An
Bord
Pleanála

Inspector's Report

ABP-309030-20

Question	Whether or not the conversion of the ground floor retail unit is or is not exempted development.
Location	45 Ferrybank, Co. Wicklow.
Declaration	
Planning Authority:	Wicklow County Council
Planning Authority Ref. no:	EX 68/2020
Applicant for Declaration:	Timo Barry
Planning Authority Decision:	Is development and is not exempt
Referral	
Referred by	Timo Barry
Owner/Occupier	Timo Barry
Observer(s)	None
Date of Site Inspection	21 st May 2021
Inspector	Suzanne Kehely

Ground Floor Plan

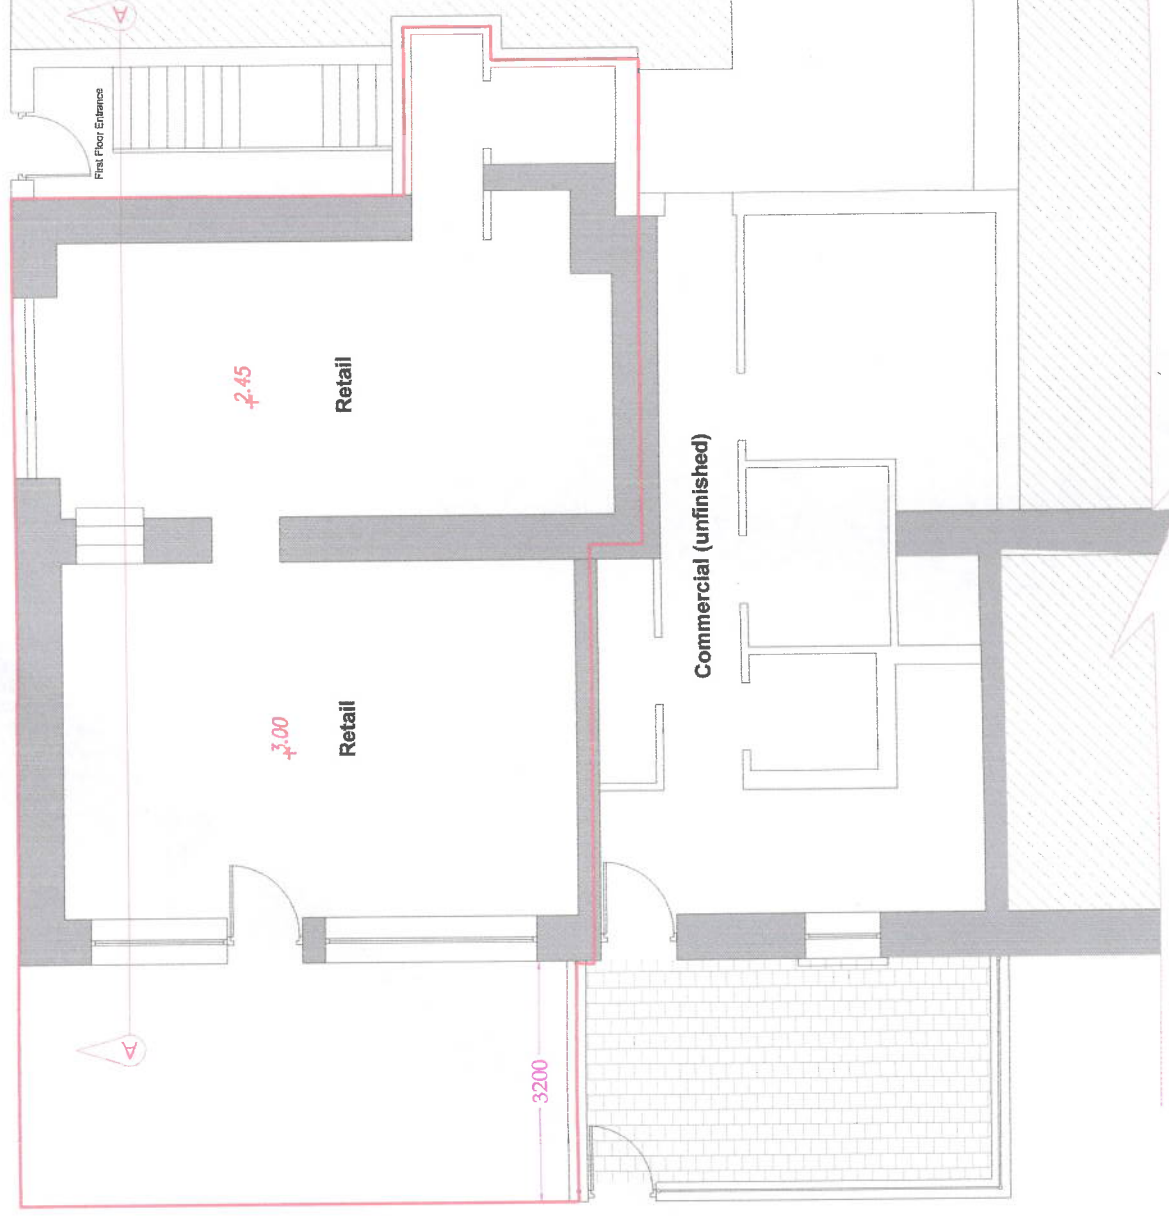
8.5.8. With respect to the floor area, the parameters are set out in SPPR 3 of the Sustainable Urban Housing: Design Standards for New Apartments - Guidelines for Planning Authorities which apply generally to apartment schemes and to purpose built managed schemes. In relation to social housing or purpose built for older people there is also provision for a 3 person apartment in line with Quality Housing for Sustainable Communities Guidance published by the Department in 2007, for application to social housing schemes. It is stated that “while providing necessary variation in dwelling size, it would not be desirable that, if more generally permissible, this type of two-bedroom unit would displace the current two bedroom four person apartment.” It is my interpretation that a reduced size (i.e. less than 74sq.m. requires to be assessed on its merits. In this case there is no statement as to the nature of use and there is no provision (if exempt) for restricting occupancy. I note that the guidelines provide for a reduced floor area of 63 sq.m and I also note this area and room configuration accords with exactly with the minimum areas as set out in Table 5.1 of Quality Housing for Sustainable Communities guidance published by the Department in 2007. These guidelines however are based within a broader framework of standards “All dwellings should have clearly defined private open space, e.g., private garden space or adequately sized balcony. New dwellings should be integrated in a way that reinforces the existing or newly created streetscape, e.g., by adopting the existing building line.” For certain types of

- 8.5.9. While it may be counterargued that the purpose of the temporary Regulations is to provide for a class of accommodation in exceptional circumstances and in this context the change of use to a lesser area of 63 sq.. may be considered acceptable, on balance I do not consider the proposed development can meet with exemption criteria in Article 6 (d) (vi) in the absence of open space.

- 8.5.10. The habitable rooms are all provided with windows of a standard size and I am generally satisfied that these rooms have adequate natural light having regard to room depths and the BRE guidelines (Site Layout Planning for Daylight and Sunlight – A Guide to Good Practice, 2nd edition). The exemption cannot be reasonably restricted in this regard.

PROPOSED

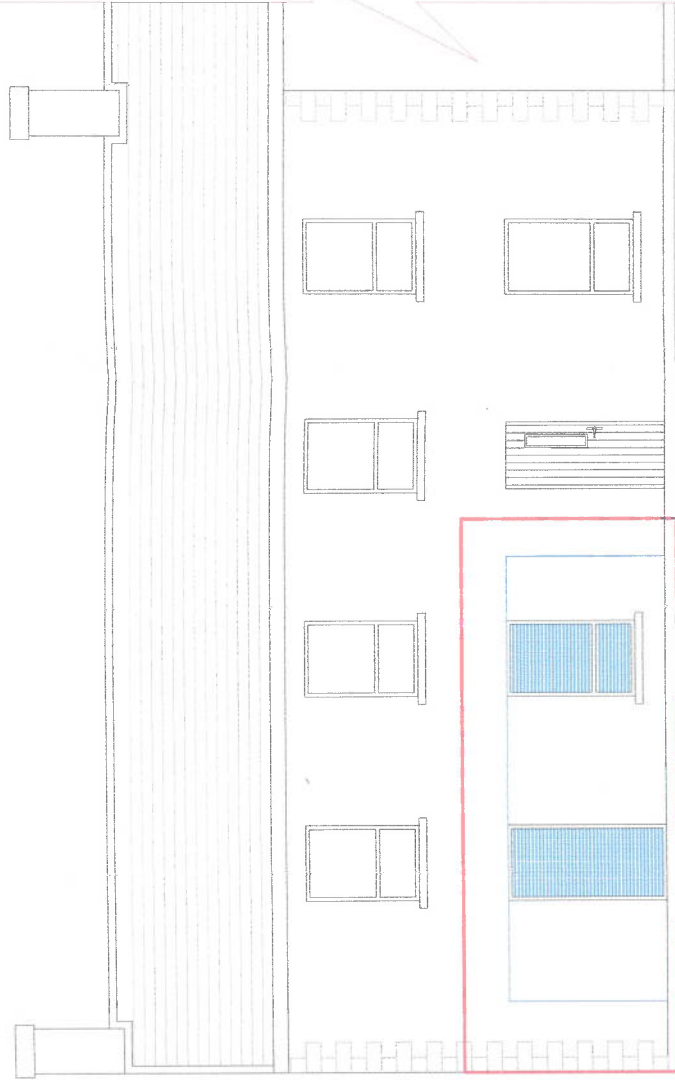
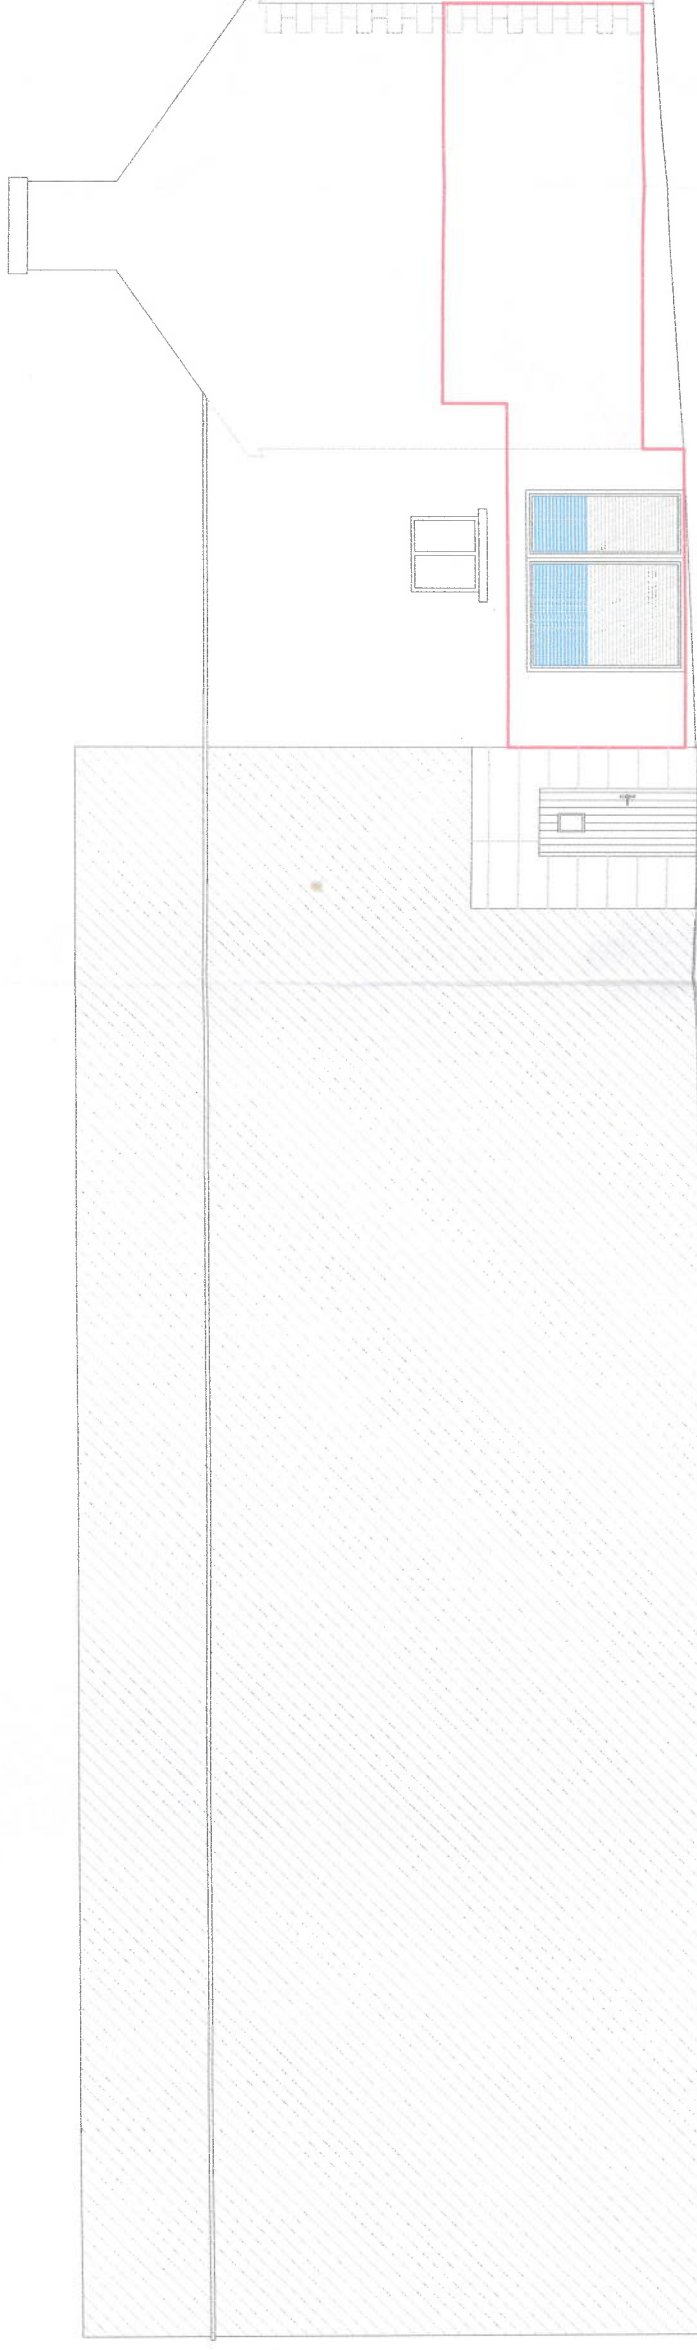
- (d)(ii)
- 8.5.4. The area to the front of the structure has been hard landscaped to match and create an extended cobble-locked footpath - its use as a pedestrian area is, it would appear, established. To reduce this uniformly paved area and alter pedestrian movement would constitute a change in its character. While it is proposed to enclose what would have been the original front garden by way of constructing a wall and railings to match that of the nearby property at no.48 and while this is

presented as ancillary works in the provision of private amenity space, I am of the opinion that the proposed wall and railings will materially affect both the external appearance and functionality of space by enclosing what has become a public footpath and will I consider be inconsistent with the character of the structure as it presently interfaces with the public realm.

- 8.5.5. The fenestration details which include vertically proportioned windows in the Ferrybank façade are consistent with the remainder of the structure and streetscape. The exemption cannot be reasonably restricted in this regard
